Re: Planning Application 20/0243 Amended

Address: 3 Bank Cottages Whalley Road Billington BB6 9NL

Description: Proposed subdivision of cottage back to two cottages and creation of four off-street parking spaces.

Simon Hardie
Highways Development Control
Lancashire County Council

PROPOSED SITE PLAN SCALE 1:200

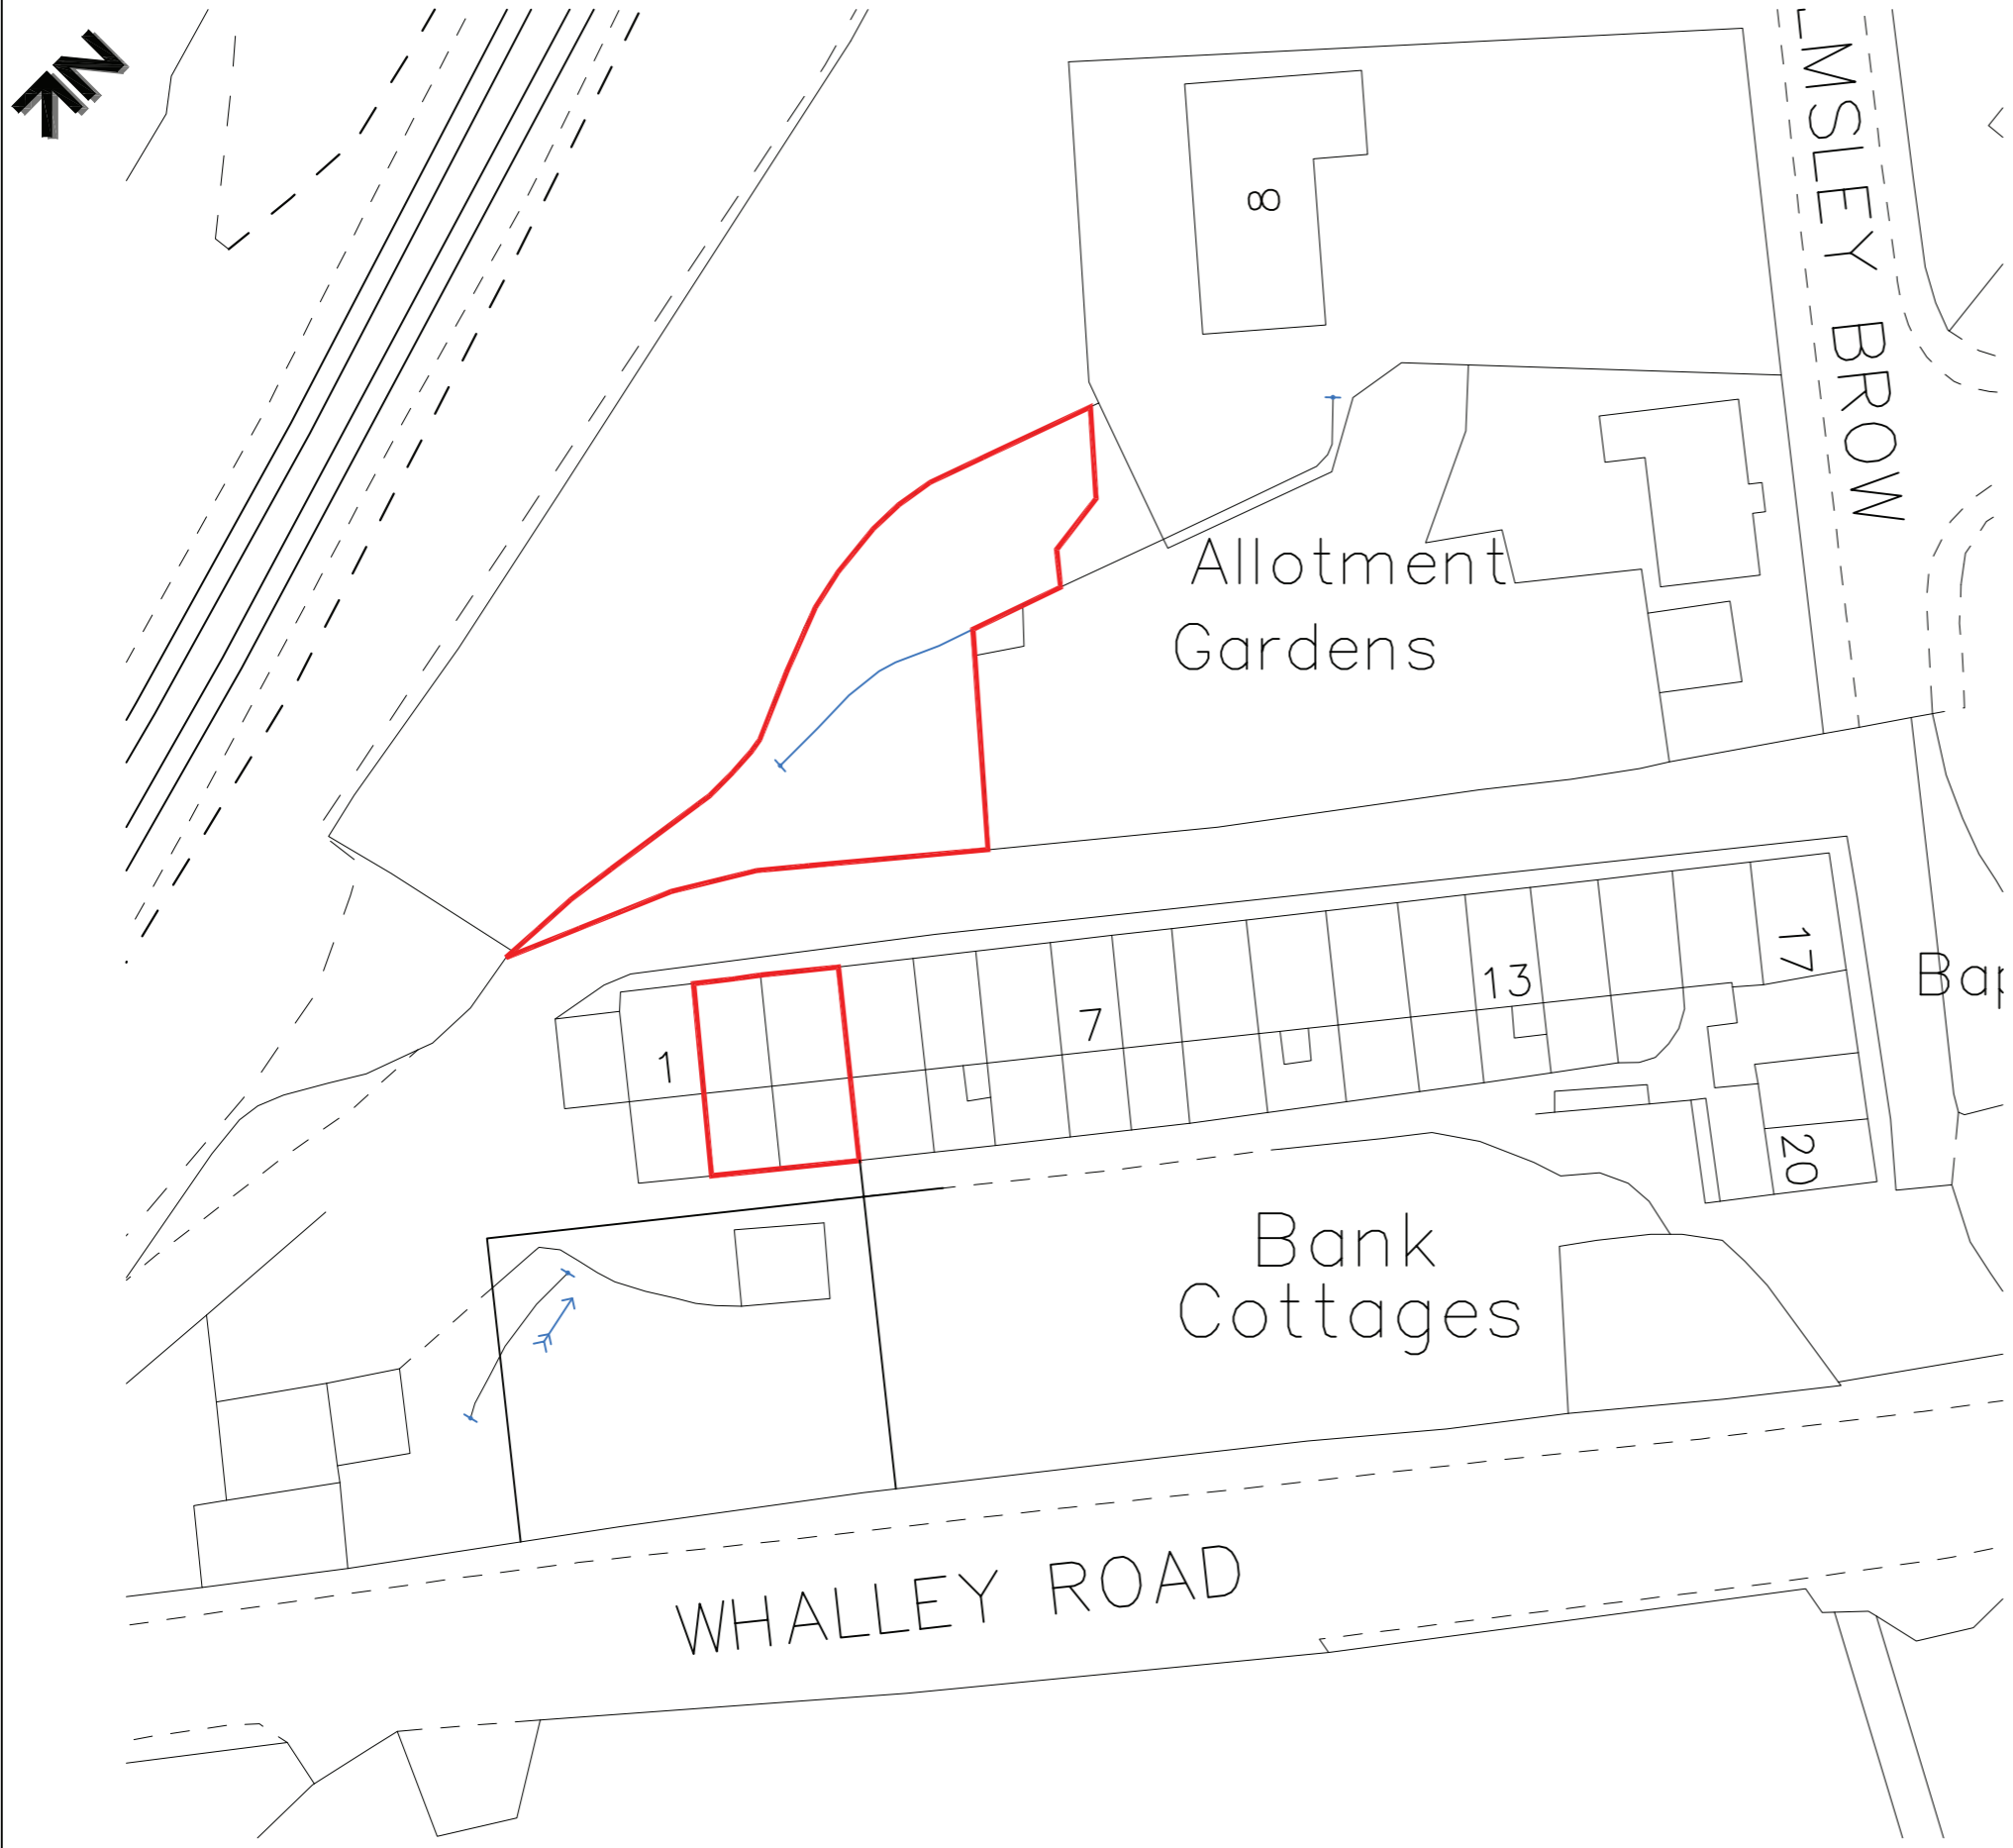
It was noted that, the earlier proposal showed an area that was to be surfaced to allow for addition road space at the pinch point. Should this be included with this amendment, it is recommended that the work to widen the access road is carried out in line with Lancashire County Council Specification for Construction of Estate Roads, to maintain the proper construction of the highway. It should be noted that this section of highway known as Bank Cottages is not part of Lancashire County Council's adopted road network.
